DRB Application No.: <u>04DRB-01239 (P&amp;F)</u>	Project # <u>1001899</u>
Project Name: <u>VILLAS TUSCANO</u>	
Agent: <u>Brasher &amp; Lorenz</u>	Phone No.: <u>888-6088</u>

**DEVELOPMENT REVIEW BOARD--SPEED MEMO**

Development Review Board Comments

THE PURPOSE OF THIS PLAT IS TO DIVIDE TRACT SEVEN (7) INTO EIGHT (8) LOTS, AND GRANT ANY EASEMENTS AS SHOWN.

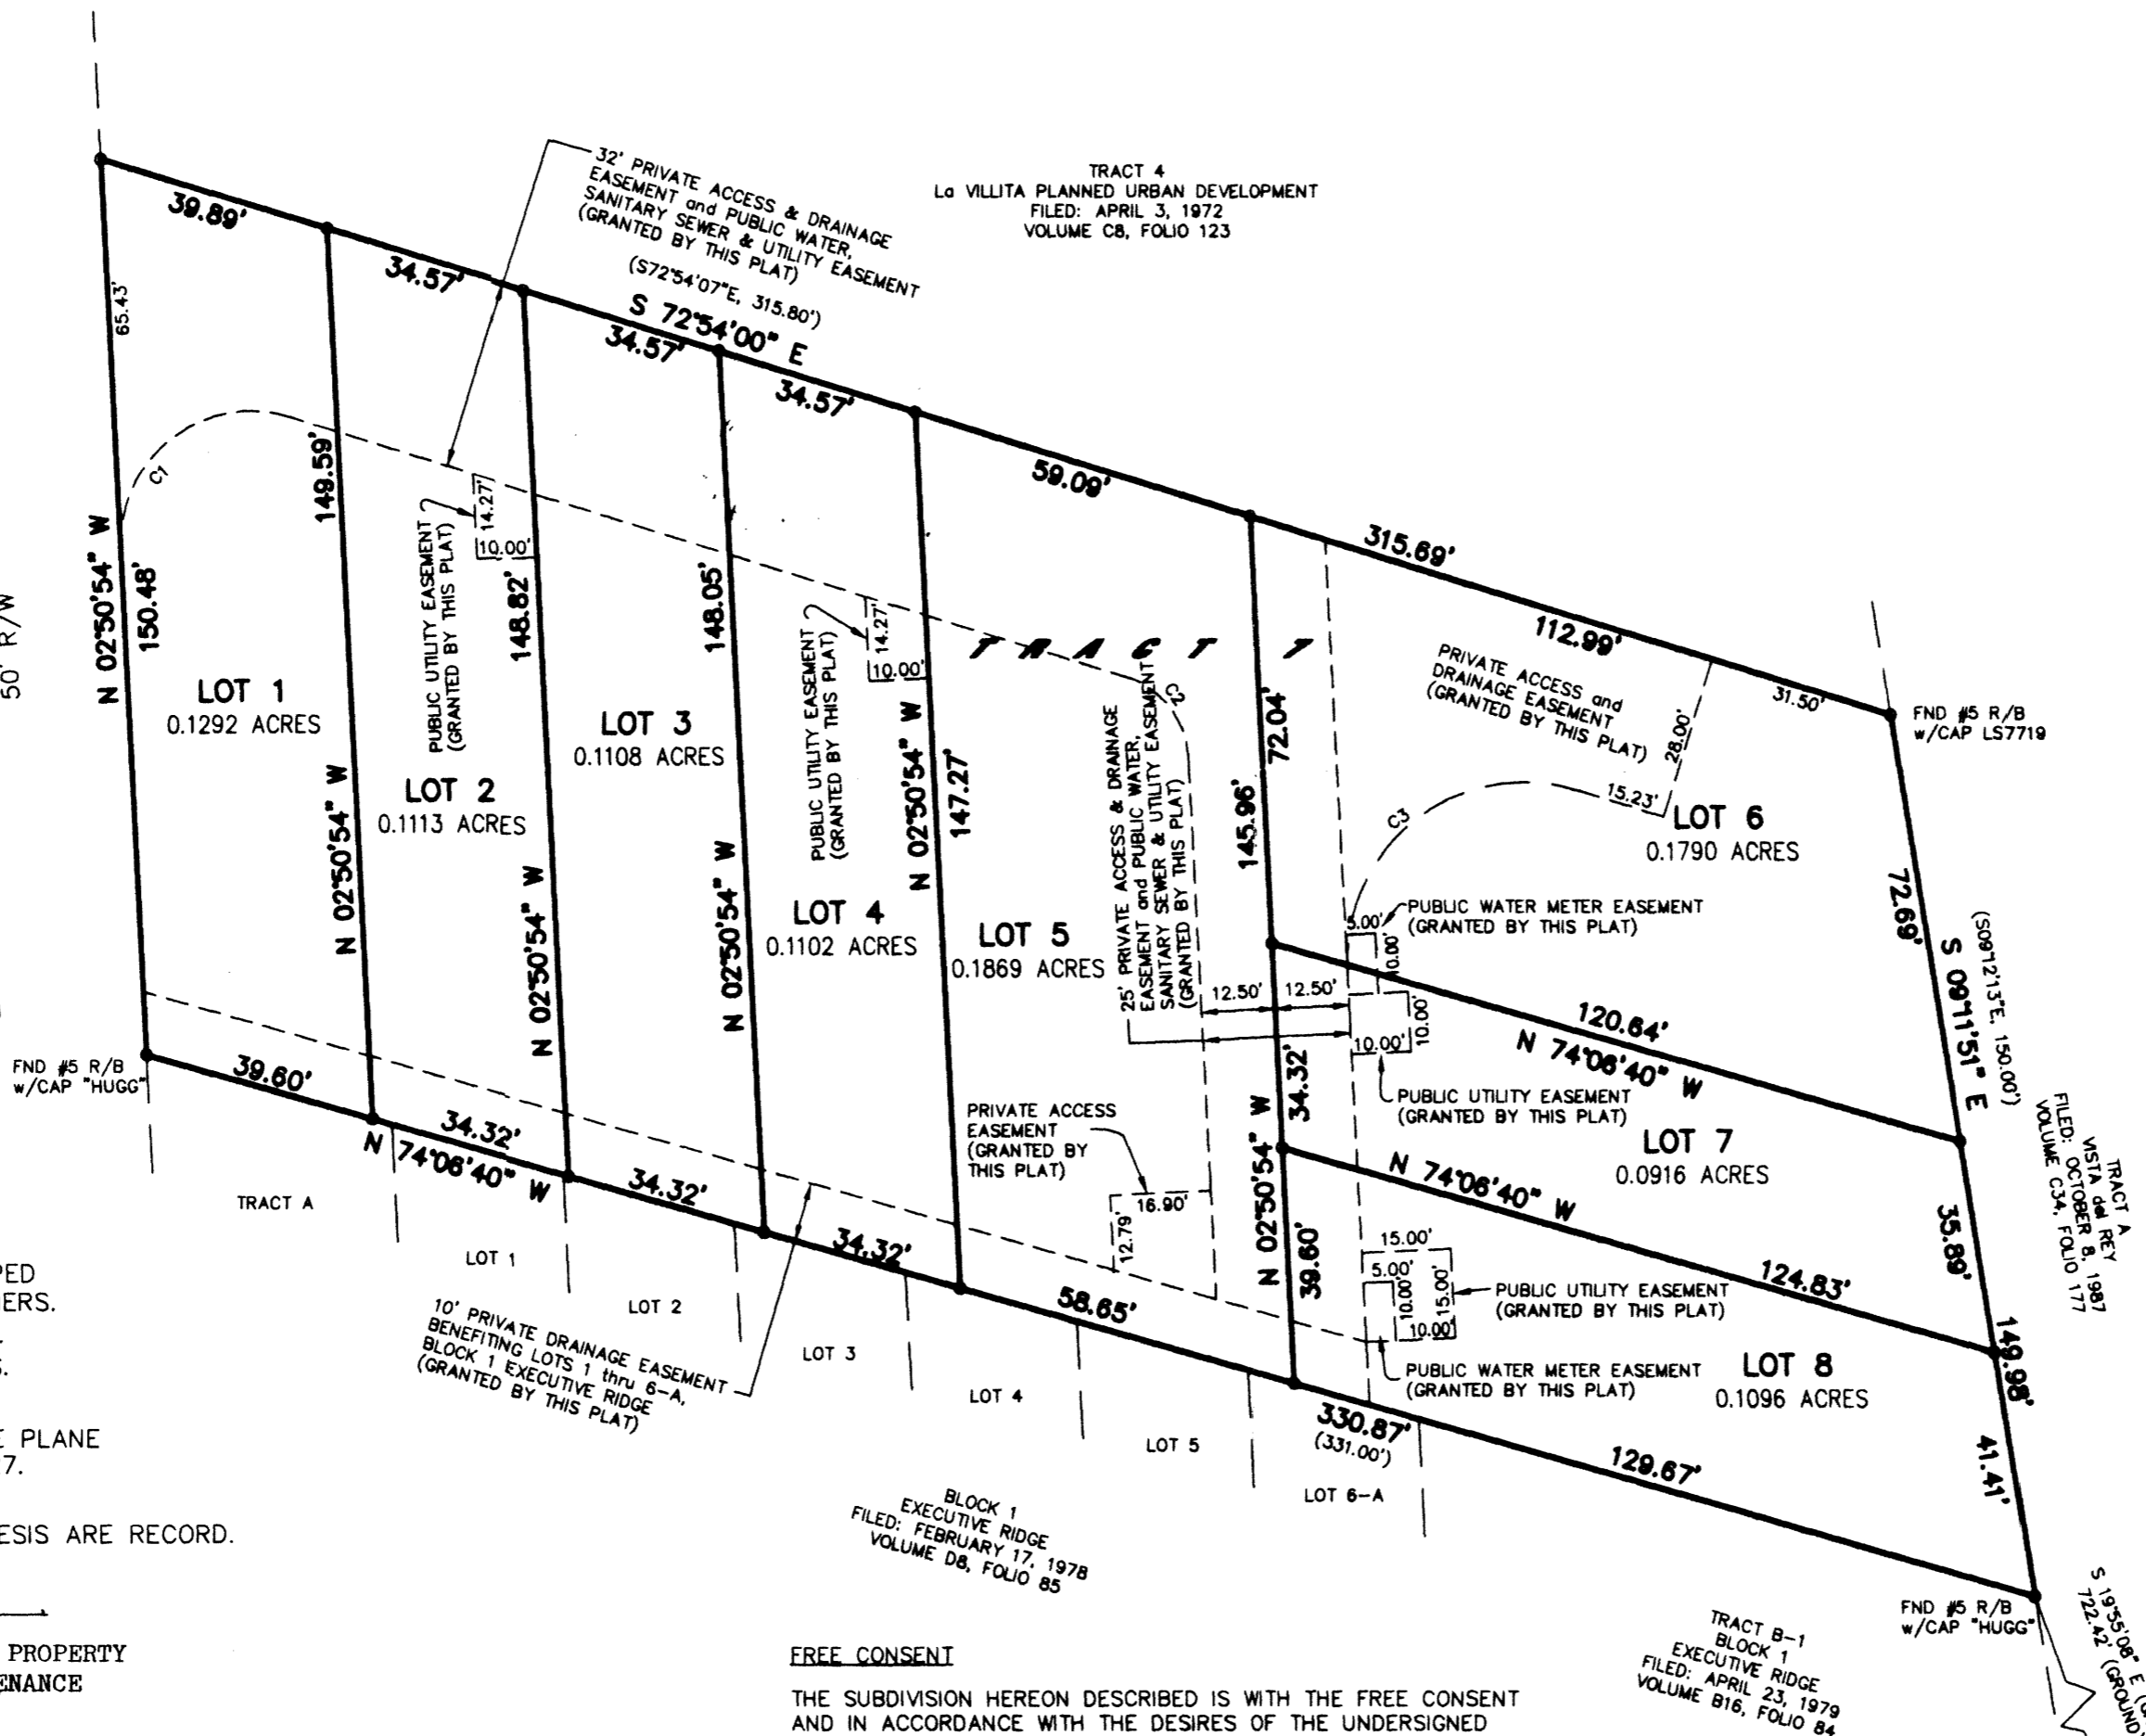
- TRANSPORTATION: RECORDING INFORMATION ON PART  
 REGARDING MAINT. & BLDG. of PRIVATE  
 ROADS. *2-10-05*
- UTILITIES: \_\_\_\_\_
- CITY ENGINEER / AMAFCA: \_\_\_\_\_
- PARKS / CIP: \_\_\_\_\_
- PLANNING (Last to sign): \_\_\_\_\_

An executed Subdivision Improvements Agreement with financial guarantees is required for Final Plat sign-off. All private easements should have maintenance responsibilities and beneficiaries stated on plat.
